# FALCON FIRE PROTECTION DISTRICT

August 18, 2020

**RE: Temporary cul-de-sacs and emergency access Saddlehorn Ranch Subdivision,**

Falcon Fire Department has reviewed the proposed "temporary" cul-de-sacs exceeding the maximum length of 1,6000 feet and "temporary" emergency access from Curtis Road for the proposed Saddlehorn Ranch Subdivision.

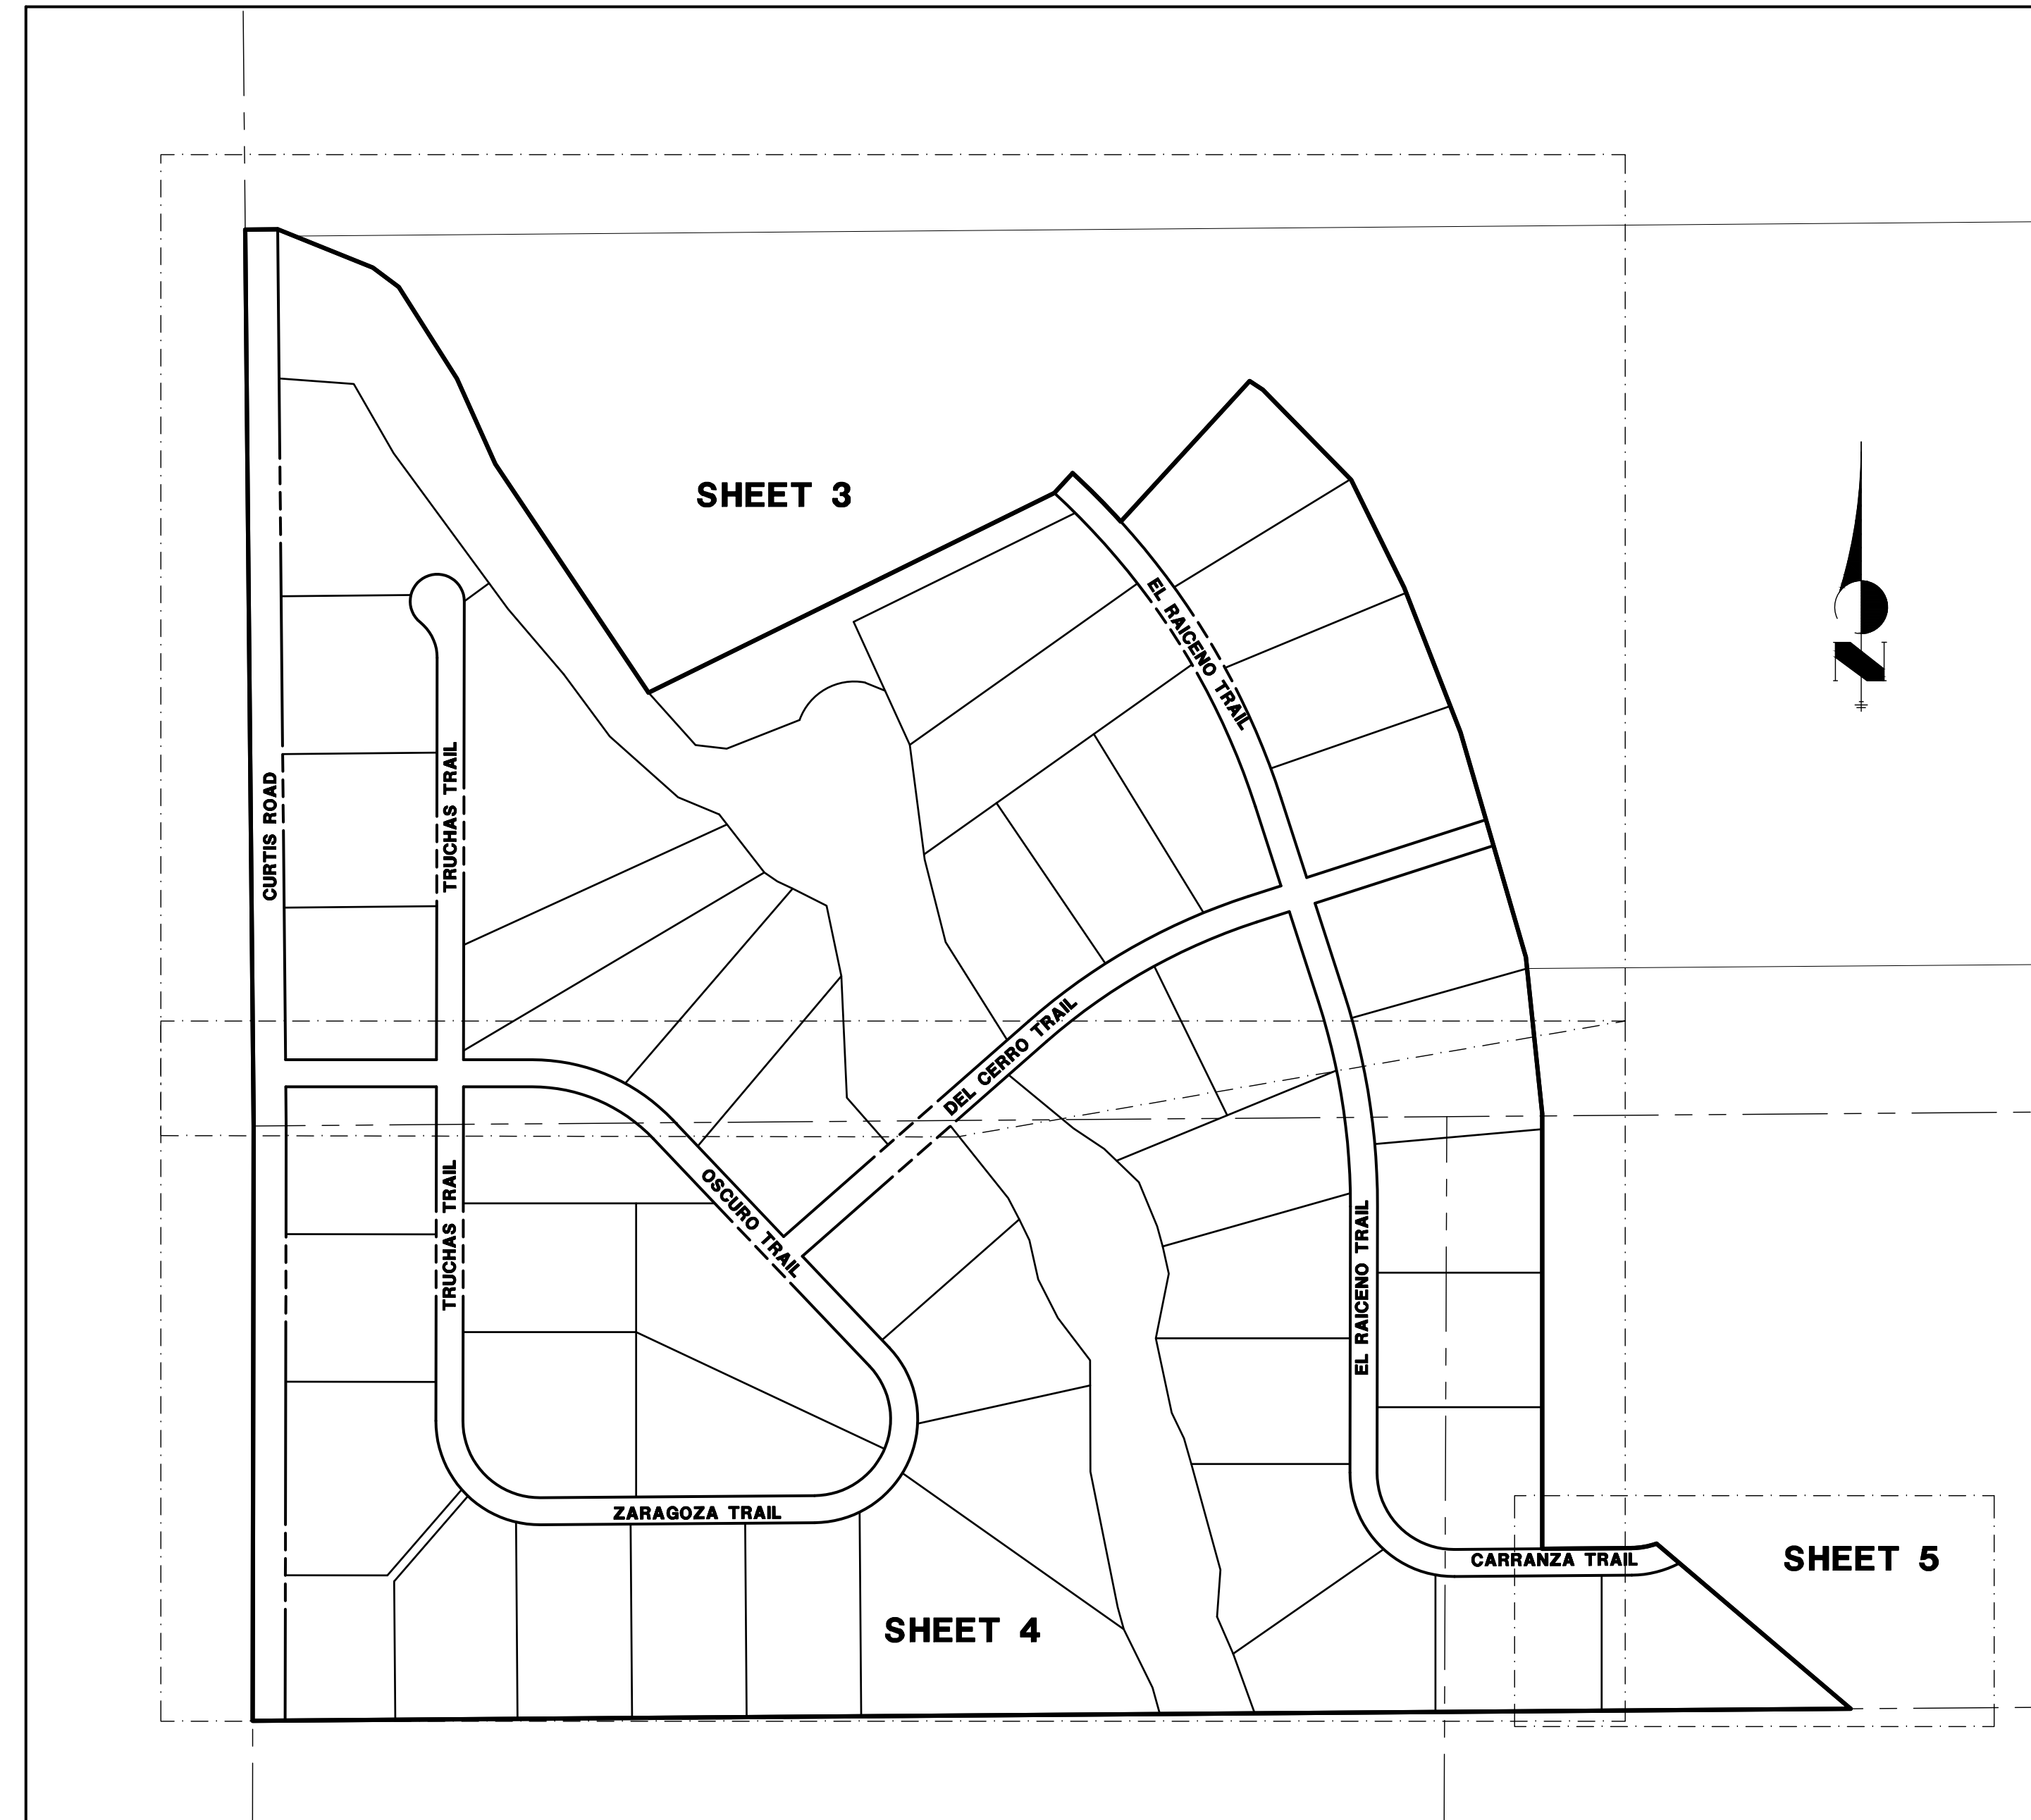
The El Raiceno Trail, Carranza Trail and Barrosito Trail temporary cul-de-sacs are exceeding the maximum length of 1,600 feet for rural condition.

The temporary cul-de-sac for El Raiceno Trail is shown on the preliminary plan at lots 50 and 102. The Carranza Trail temporary cul-de-sac is shown at lots 68 and 69. The temporary cul-de-sac for Barrosito Trail is shown in the southeast corner at lots 103 and 104.

These conditions are temporary and Falcon Fire has no objections to these requests as long as the emergency access and temporary cul-de-sacs meet minimum county standards for width, turning radius and loading.
